## REQUEST

Current Zoning: R-17MF (multi-family residential)  
Proposed Zoning: UR-2(CD) (urban residential, conditional)

The petition proposes to redevelop a site with 18 existing multi-family units to allow for the development of 21 new townhomes.

RZ-1.0

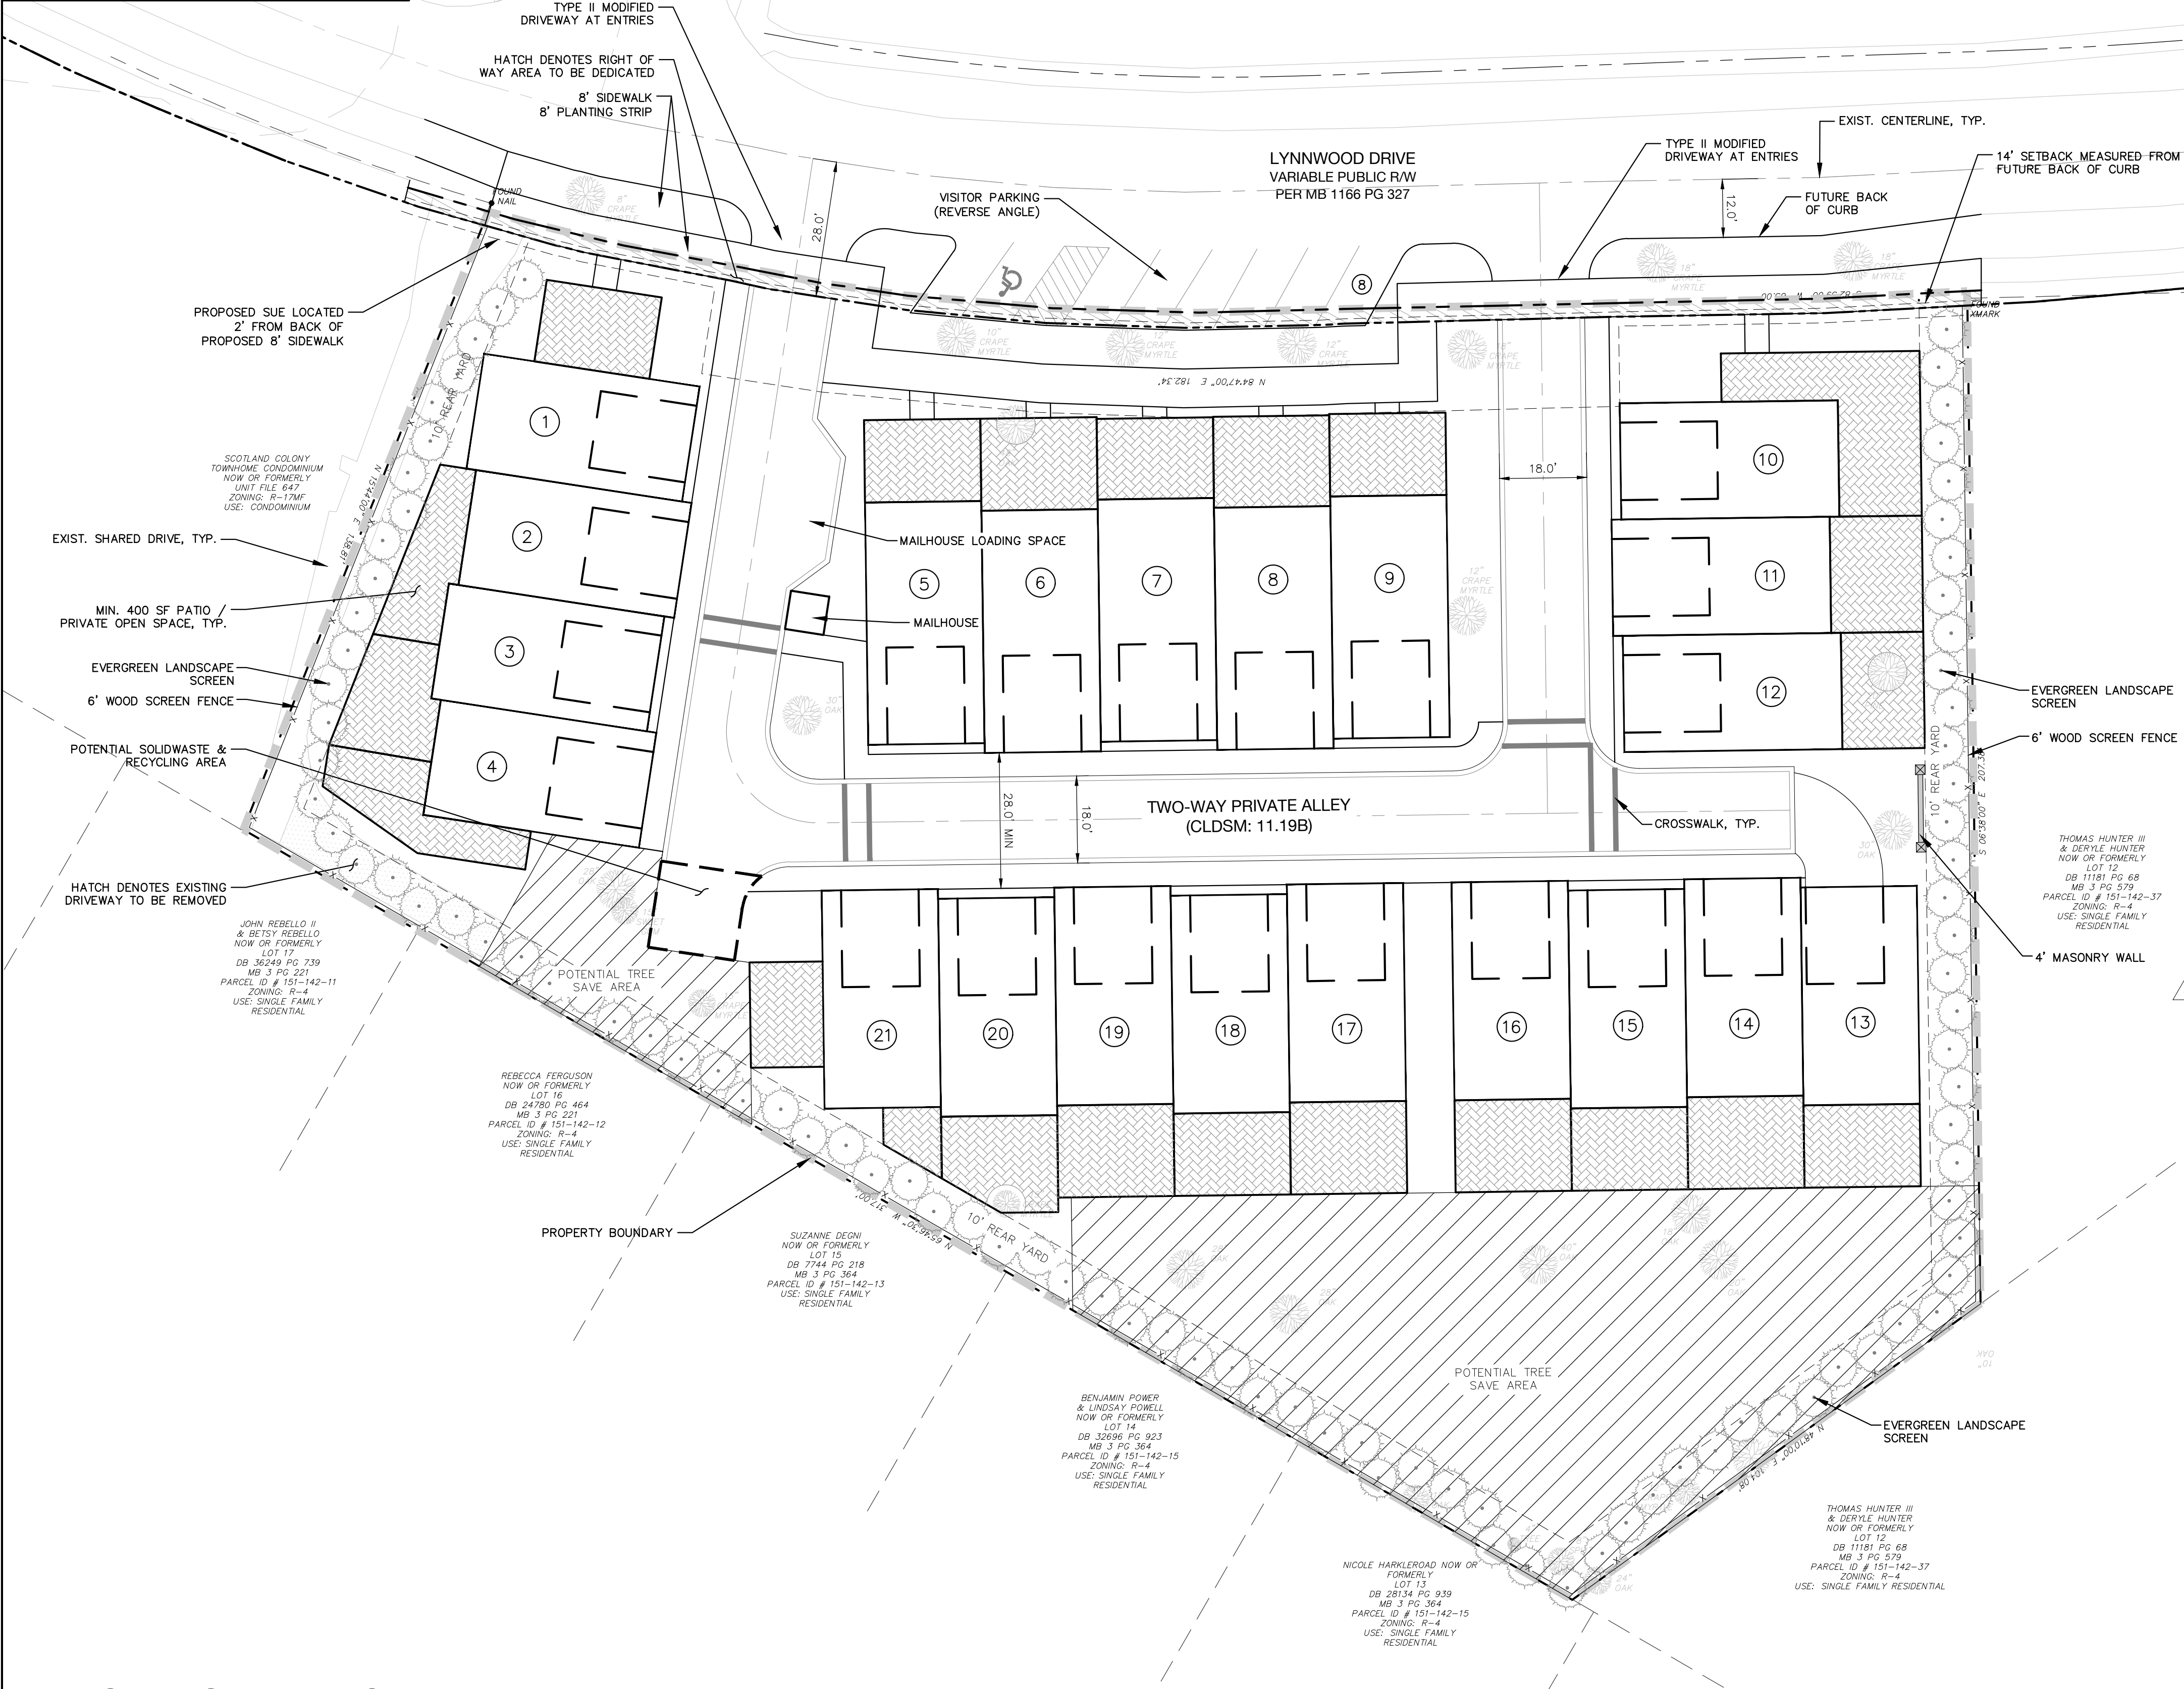
1. ~~Label and dimension the curb and gutter from the centerline for each road on the site plan. The site plan should show dimensions as measured from the centerline to the back of curb.~~ **Addressed**

2. ~~Remove language allowing additional height beyond 40' in note g. under Architecture and Design Standards.~~ **Comment Rescinded**

3. ~~Clarify in the conditional notes that the arborist plan will be done prior to development plan submittal and clearly identify which trees outside of the tree save area are to remain.~~ **Addressed**

4. ~~Add note that patios shall be at-grade and covered.~~ **Addressed**
5. ~~Add language in the conditional notes specifying that the open space requirement is being met with private open space, as shown on the site plan.~~ **Addressed**

6. ~~Revise the language in note 6 of Environmental Features to clarify the rate of new plantings to existing trees.~~ **Addressed**
